Modifications to Accor Sofitel Hotel Site 4A, Olympic Boulevard Sydney Olympic Park

SECTION 75W APPLICATION

Submitted to: NSW Department of Planning

Date: 17 January 2007

Project:
SOFITEL HOTEL
SYDNEY OLYMPIC PARK
OLYMPIC BOULEVARD HOMEBUSH
Drawing Title:
CHANGES TO EA-APPROVED FACADE
NORTH ELEVATION

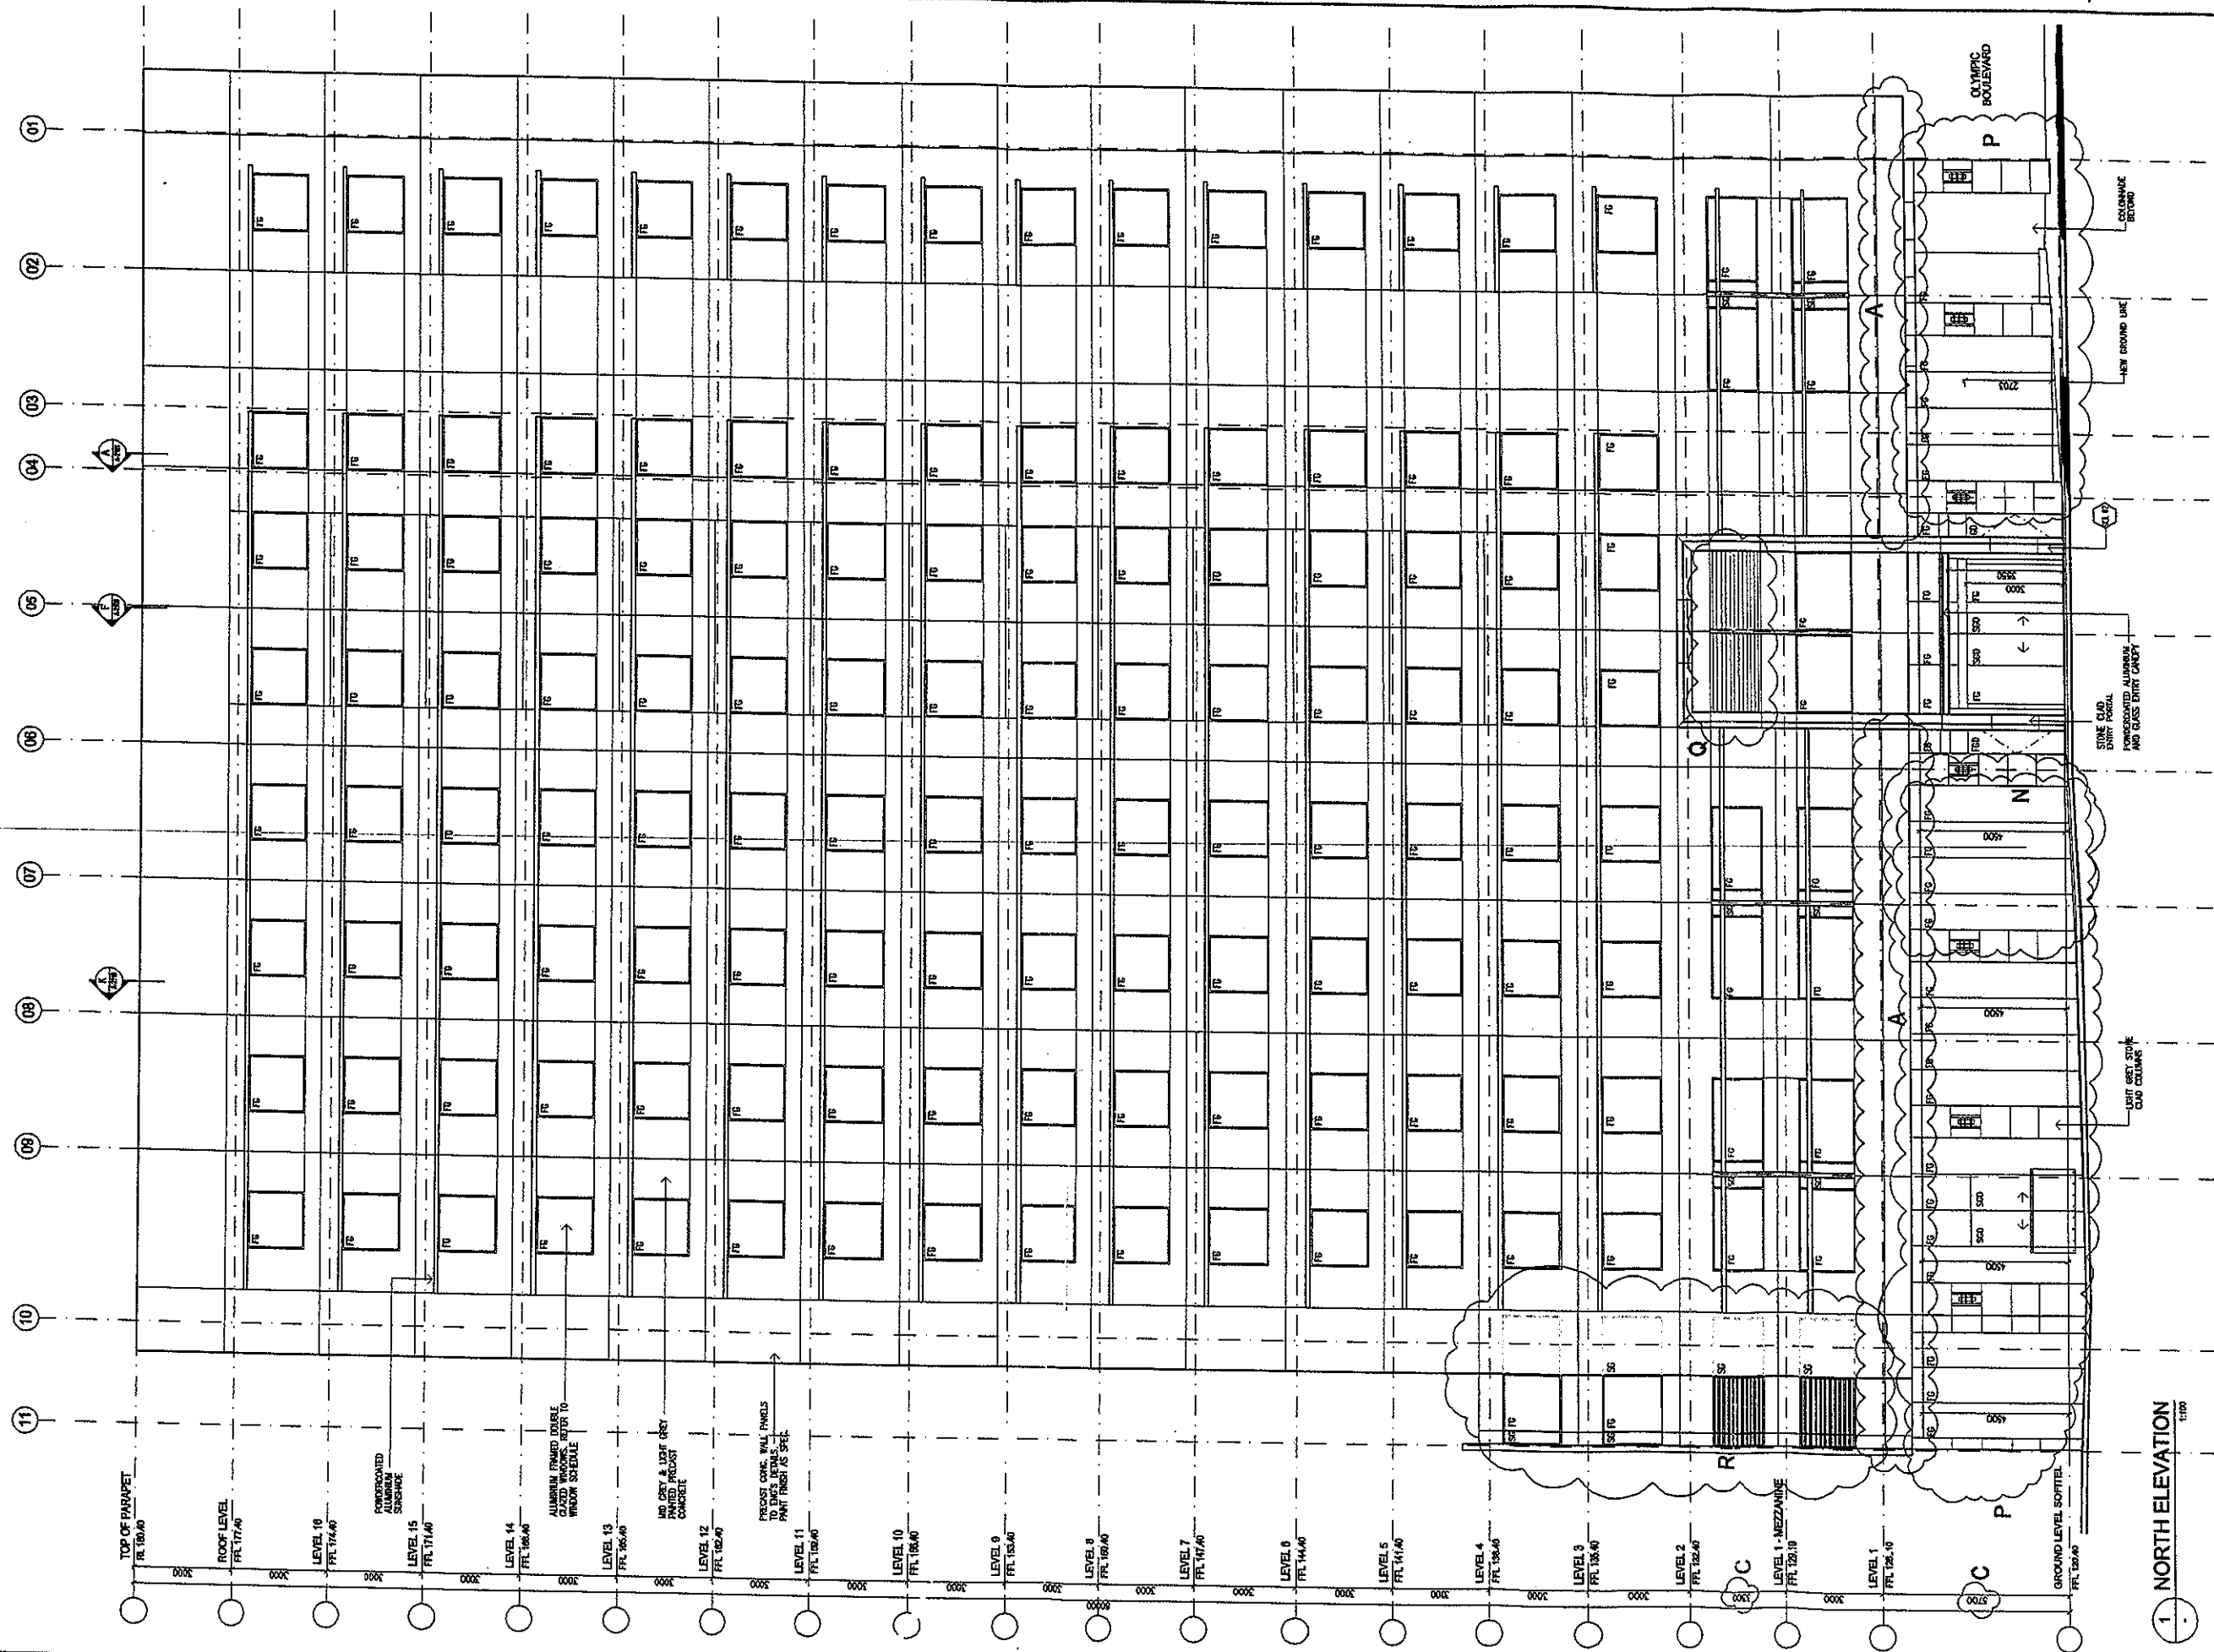
- A An increase to the floor to floor height of the mezzanine level by 300mm with a subsequent reduction in the floor height on the ground level also by 300mm. This modification has occurred to provide sufficient mechanical services reticulation to the public spaces on Level 1. There is no overall increase in the building height, simply an alteration of heights between the Ground Floor and Mezzanine levels to accommodate services. The effect of the modification is a drop in the hem of the precast panels of the main north and south facades.

- B Not used
- C Refer to comments in A. This is the subsequent increase in height of 300mm for the Level 1 Mezzanine.
- D Introduction of small plant items on the roof of the Level 4 podium which evolved during design development of the final services requirements. The plant will be screened from distant view using a powdercoated or equal finish open louvre system.

- E In reference to comment A, the baseline of the adjacent lightweight cladding was reduced by 300mm in order to maintain the original continuity of lines around the base of the building.

- G Inclusion of ventilation louvres as noted on the building facades.
- H The inclusion of steel struts at the top of the parapet above roof level. The struts will be finished in the same colour as the precast panels and the bulk of the structure is located below the adjacent lower parapet to eliminate the diagonal brace. The struts are required to support the cantilevered parapet walls. Further detail is provided on sketch detail SK-46 prepared by Hyder Consulting (See Appendix 2).

- J The midway transom is proposed to be lowered 1100mm above landing level at balustrade height to the glazing of the main tower staircases. This design change occurred due to the requirement for a safety balustrade above the landing which introduced a second horizontal line. To eliminate the second line, it is proposed to lower the midway transom.

- M The fire control room door on the southern elevation is proposed to be deleted and relocated.
- N It is proposed to recess the proposed glass line of the entrance lobby to the left of the entry portal for one bay. This area is proposed to be utilised by the hotel concierge for the temporary location of luggage trolleys. The recess is proposed as a continuation of the colonnade.

- O Not used
- P It is proposed to change the ground floor glazing to the restaurant, bar, lobby, reception and retail areas to full height frameless glass. This is to increase activation of these space and interrelationship with the public domain.

- Q Aerofoil louvres are proposed above the main entry portal and are required for the termination of the main smoke exhaust system for the public areas of the building. Sketch details SK-47 and SK49 provide further information (Appendix 2).

- R Proposed modifications to the fenestration and louvre design as detailed on the plans.
- S It is proposed to replace the vision glass with spandrel glass on Levels 2 and 3. This is to achieve more satisfactory furniture arrangements and there is no change to the size or location of the windows.

- T It is proposed to modify slightly the panel joints in the precast system as noted on the attached drawings.

ROOF PARAPET BRACING SECTION DETAIL

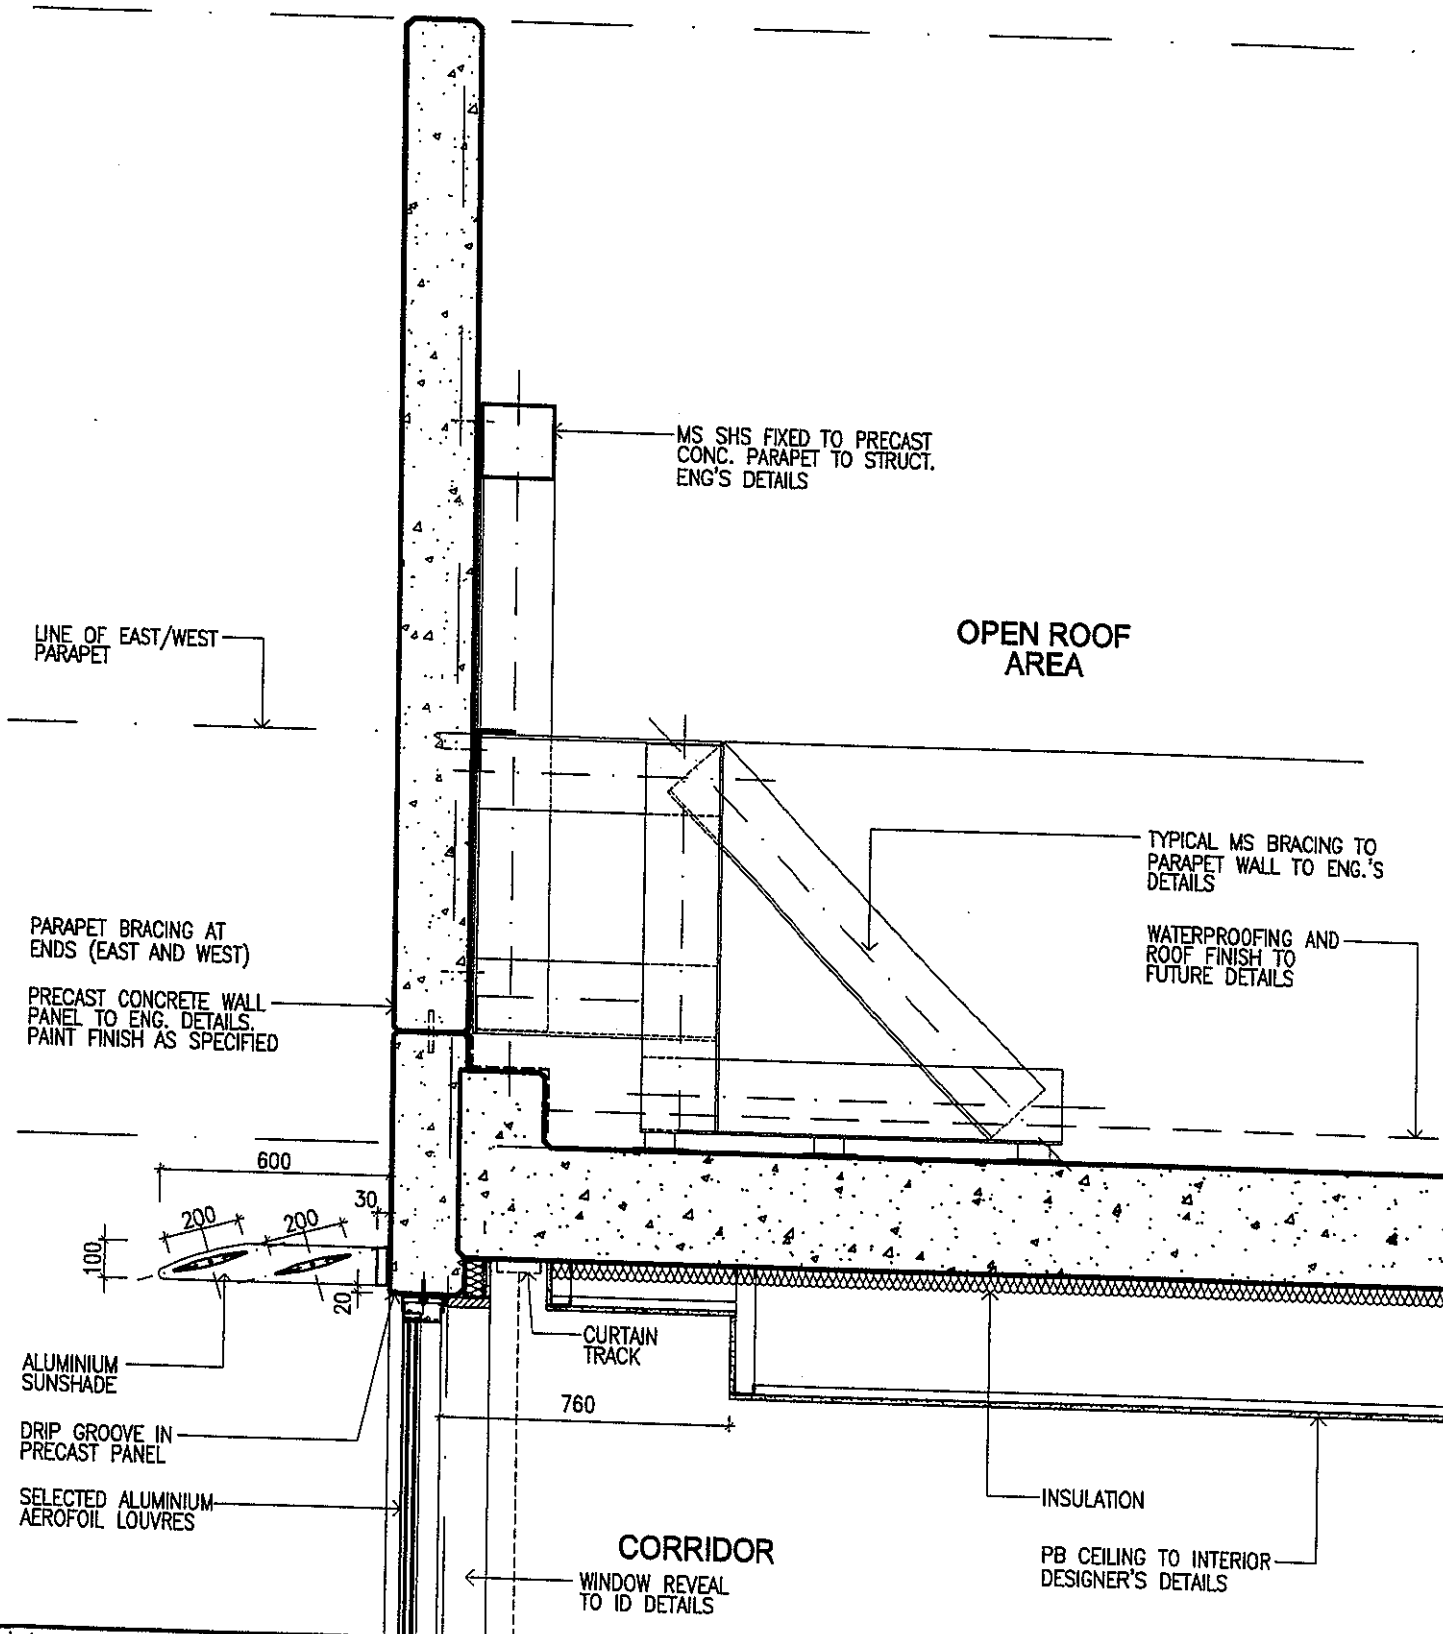
In terms of the steel struts to the parapets at roof level, the architects have located the bulk of its structure below the adjacent lower parapet to reduce the brace structures. The struts will also be finished in the same paint colour as the precast panels and will therefore not be visible from the public domain. The architect has prepared some mark ups of the original photomontages which illustrate the visual impact of the proposed strut design (see drawings in Appendix 2).

Project
SO F I T E L
SYDNEY OLYMPIC PARK
OLYMPIC BOULEVARD HOMEBSH
CHANGES TO EA-APPROVED FACADE
WEST ELEVATION

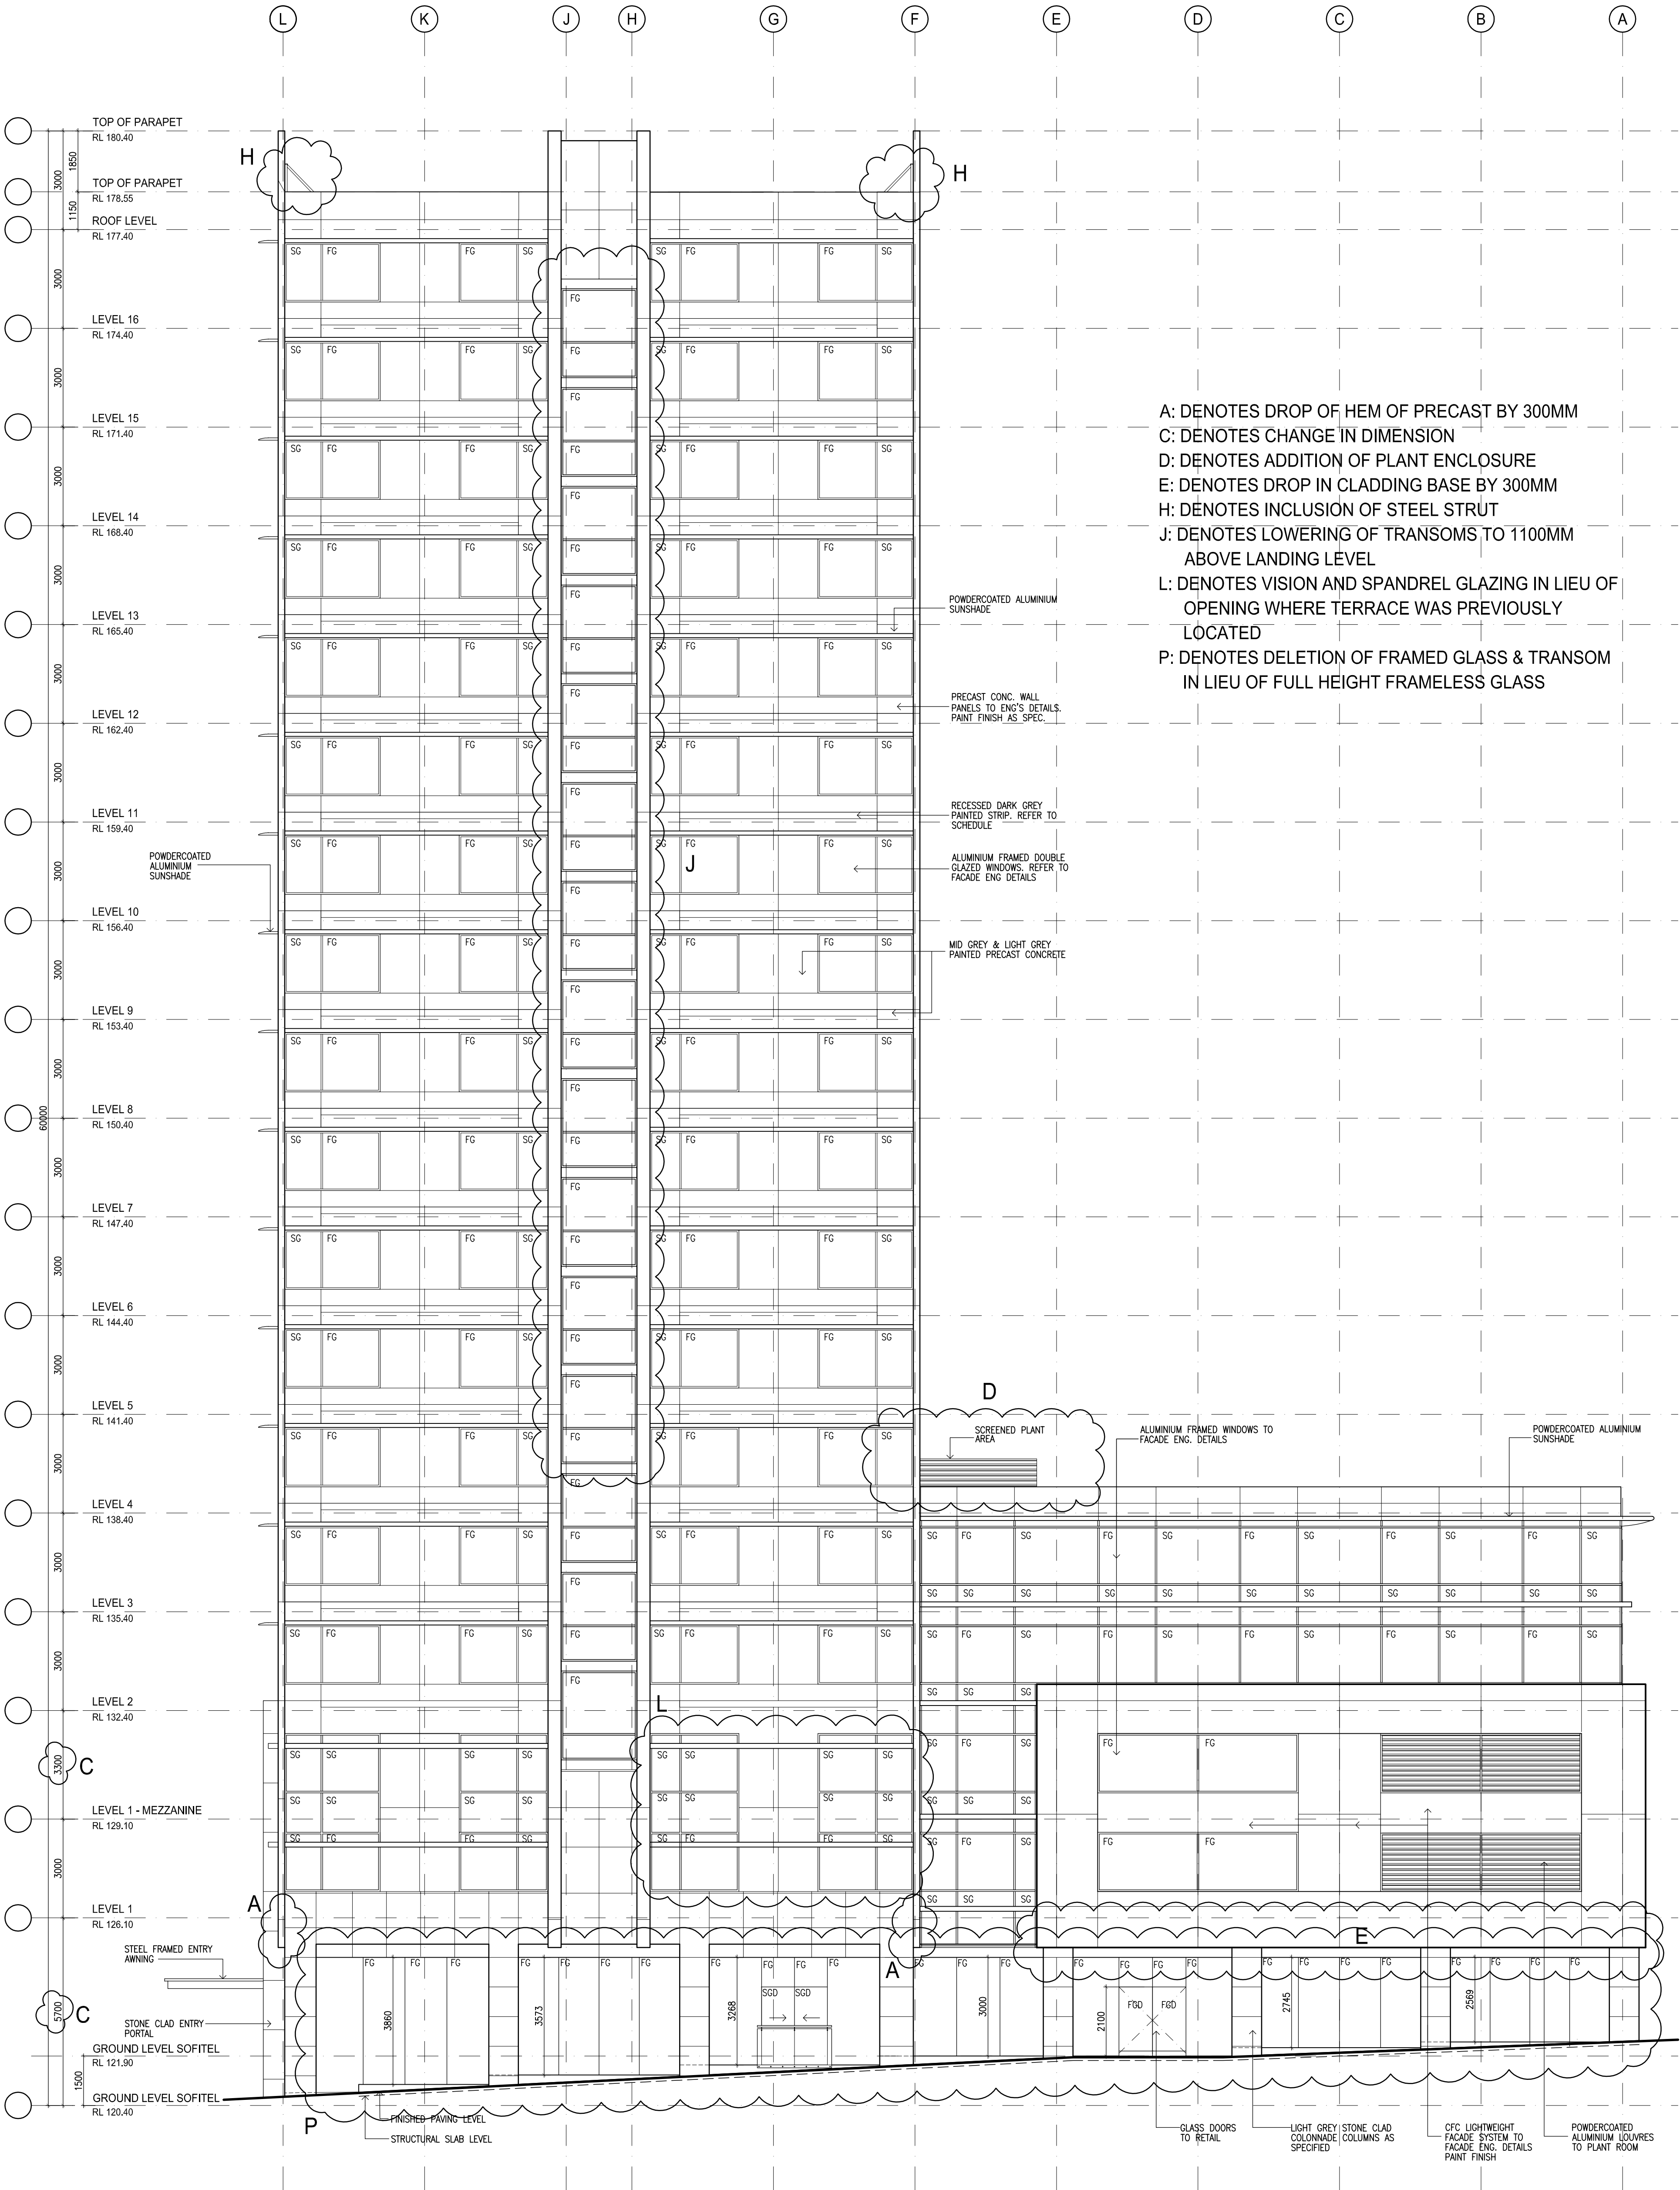
- F Following receipt of the final Energy Australia requirements for the substation, steel framed louvre doors are provided to the substation room. The feature blades above these doors were not intended to project as far and have been shortened to suit the requirements.
